South Yorkshire Fire and Rescue (SYFR) response to ExQ1 (issued 9th May 2025) relevant reference points.

Ref:	Question to:	Question:
1.13.13	South Yorkshire Fire and Rescue Service	The ExA notes that the applicant has referred to the Draft Guidance on Grid Scale Battery Energy Storage Systems (BESS) by the National Fire Chiefs Council (the 2024 document) within the fBSMP [APP-205]. Please comment on the appropriateness of using this document instead of the 2022 guidance.
South Yorkshire Fire and Rescue response to Ref 1.13.13		<p>The recent NFCC draft document, is draft and awaiting publication, however it should be acknowledged that this document has been used across the sector and referenced by professionals and members of the public for other recent consultations.</p> <p>Anything referenced from the guidance, where appropriate, should be supported by other documentation or guidance. For example, the spacing to BESS containers. Manufacturers' guidance, testing data, UL certification and NFPA 855, along with any other appropriate guidance should support the siting of containers.</p> <p>SYFR standard response to BESS planning application regarding the guidance of relevant guidance

Plate 2-1: BESS Area Indicative Layout

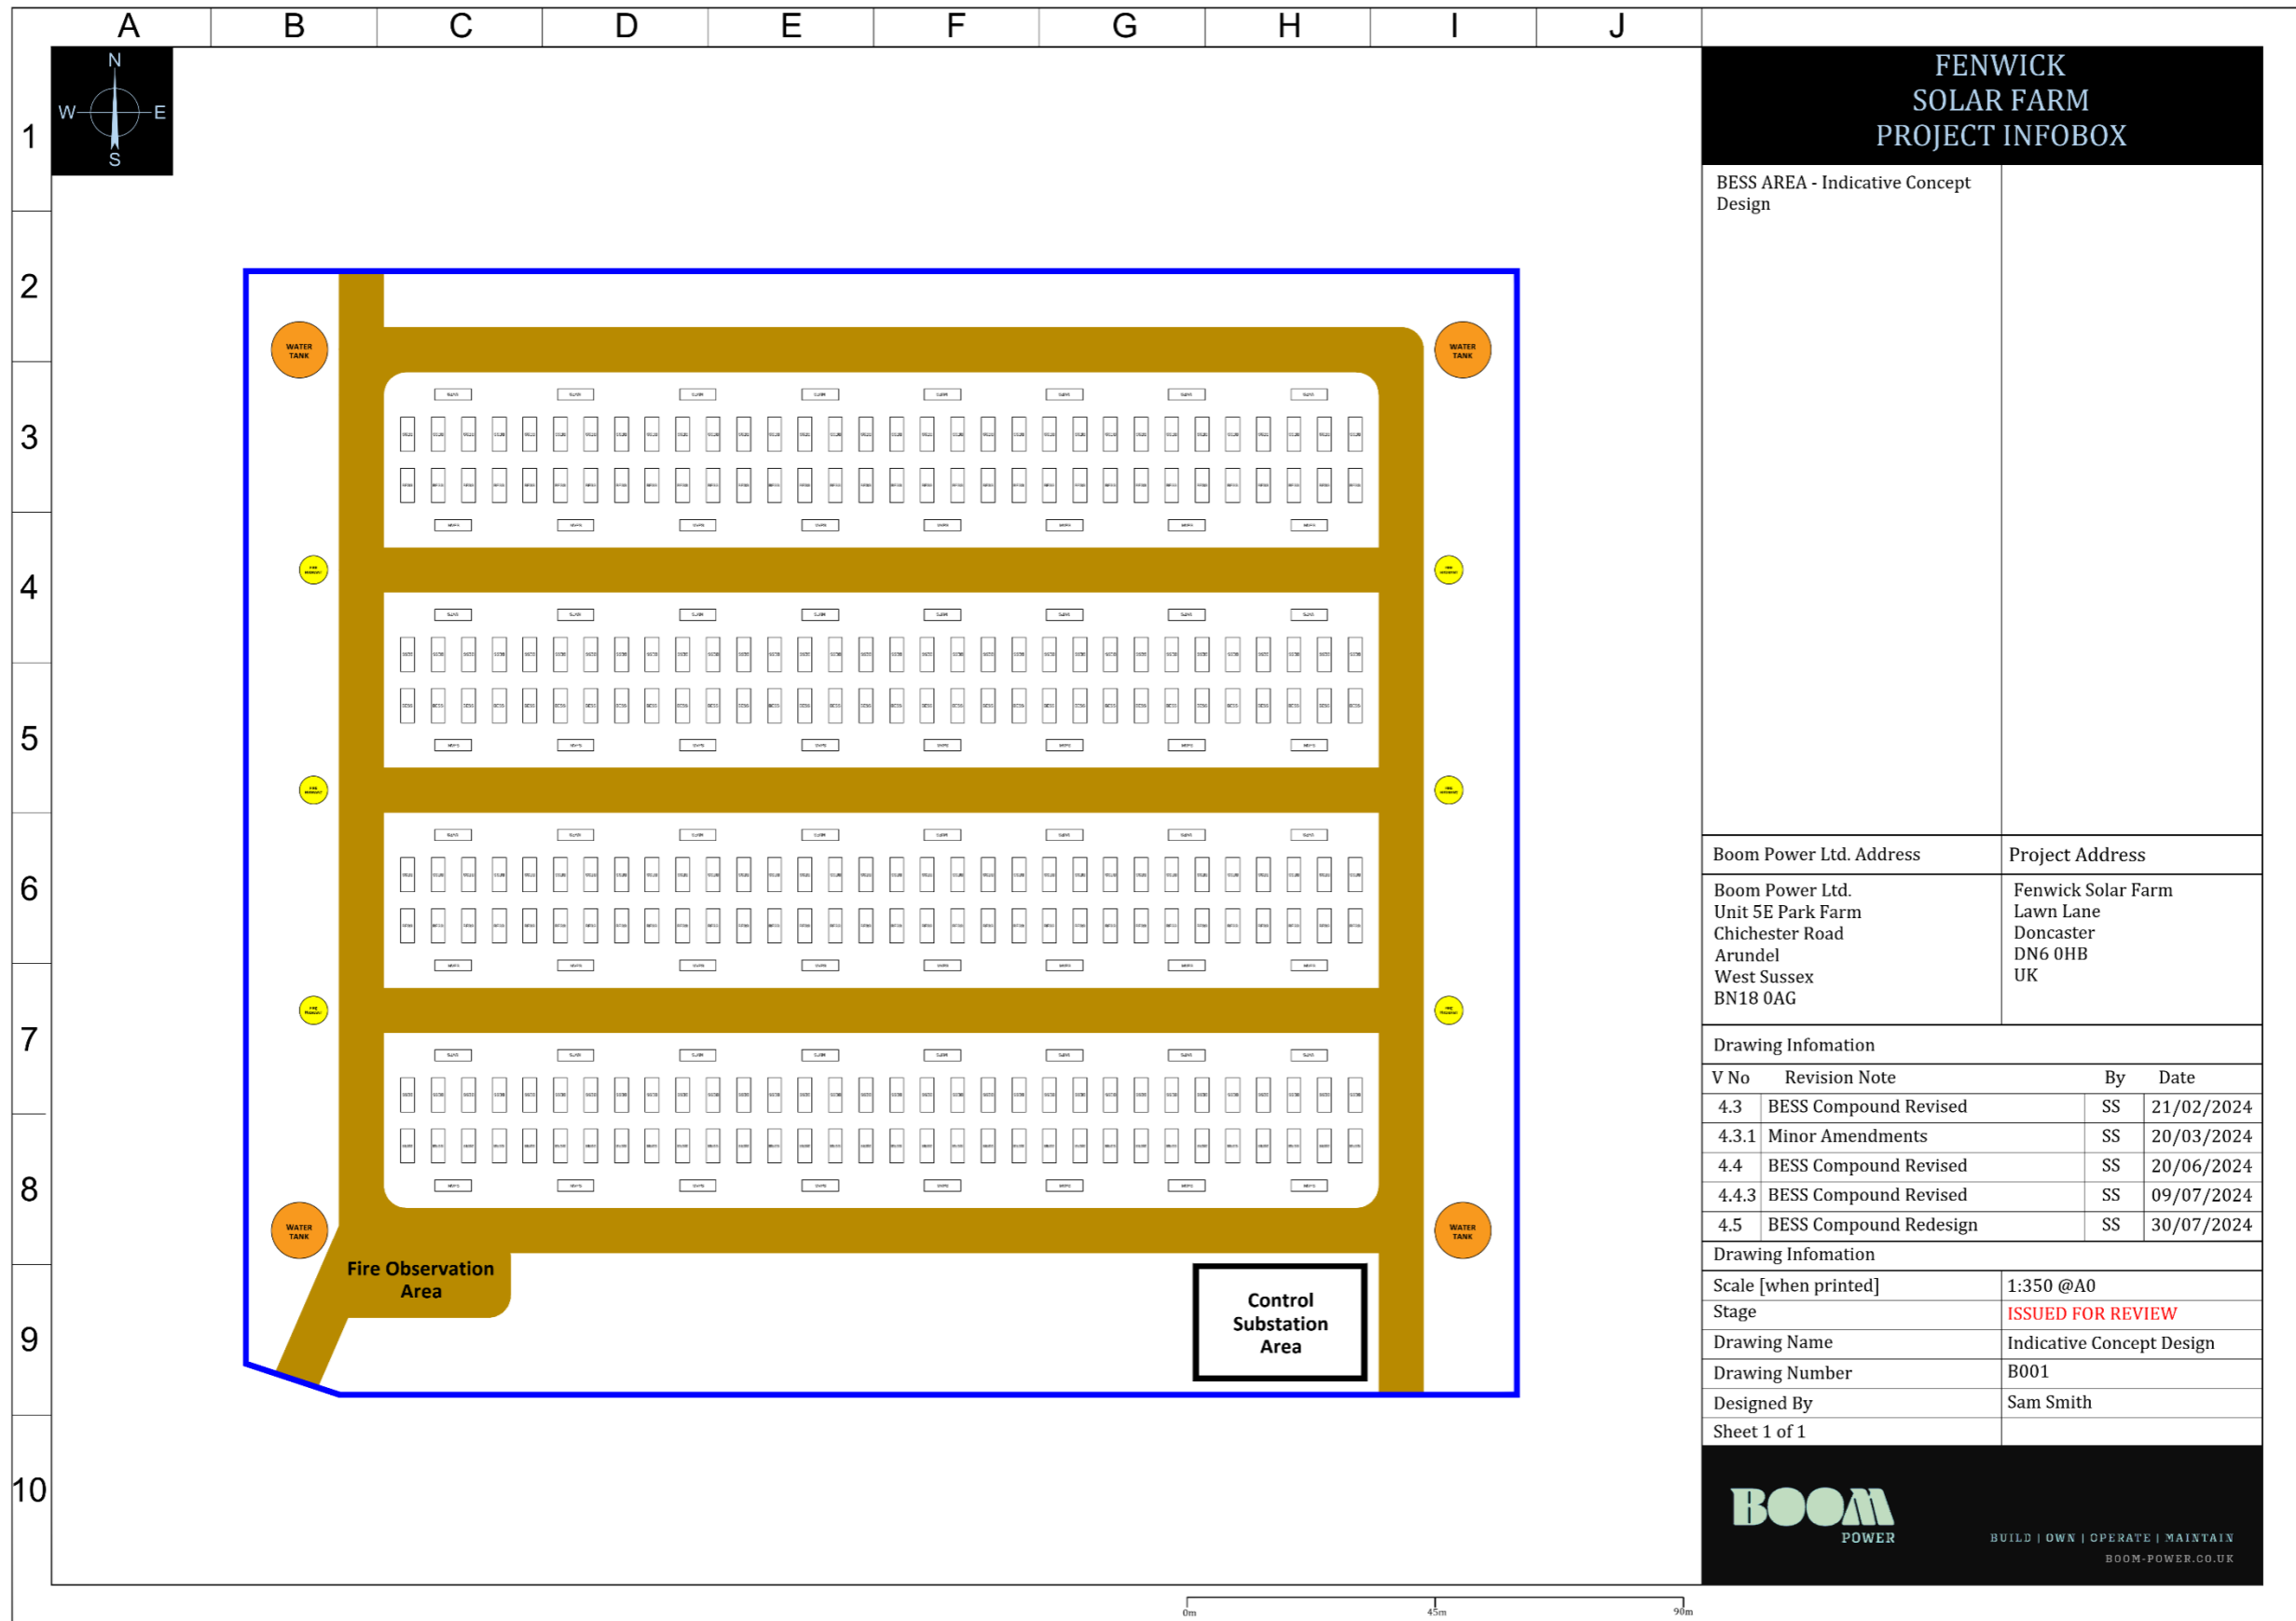
1.13.15	South Yorkshire Fire and Rescue Service	Please comment on the proposed reduced distance of 3m between BESS units as stipulated within fBSMP [APP-205] paragraph 2.1.23 and that the applicant states they can demonstrate suitable design features for this

<p>South Yorkshire Fire and Rescue response to Ref 1.13.15</p>	<p>Fenwick Solar Farm Project Limited though the proposed Statement of Common Ground (SoCG) have addressed this reduced distance is suitable based on design features. SYFR will continue to consult on this throughout, using up to date information available as the project progresses and further information relating to the specific BESS to be sourced and used has been determined.</p> <p>Testing information and certification should be sought, to determine suitability of spacing.</p>
<p>1.13.16 South Yorkshire Fire and Rescue Service</p>	<p>Further to the comment made in your relevant representation [RR-009] please comment on the fBSMP [APP-205] in relation to:</p> <p>a) the nature and number of the proposed accesses to the BESS please see Figure 2-3 Indicative Site Layout sheet 5 of 11 [APP-074].</p> <p>b) The volume of water supply proposed.</p> <p>c) The measures to contain fire water.</p>

<p>South Yorkshire Fire and Rescue response to Ref 1.13.16</p>	<p>Within the SoGC, Fenwick Solar Project Limited have addressed the access, water supply and measures to contain fire water.</p> <p>a) The applicant has committed to: <i>“Two access points to the BESS Area have been provided to allow flexibility for emergency services. The access track is suitable for all SYFRS appliances, designed to support their weight and have a width of 8 m which will be maintained over the lifetime of the Scheme. There are no dead-end routes within the Order limits”</i></p> <p>SYFR have provided the applicant with appliance dimensions and weight to ensure appropriate access is given. Access to site is provided at different locations, and track access given around the site.</p> <p>b) The applicant has proposed, “four pressurized water tanks, supplying 720,000 to 976,000 litres of water, are provided to manage fires in the BESS Area” this is in line with the recommendations of the guidance.</p> <p>c) The applicant has made proposals for the management of firewater to prevent impacts to sensitive receptors from contamination.</p> <p>It should be ensured these proposals are provided during construction, if planning was to be granted.</p>
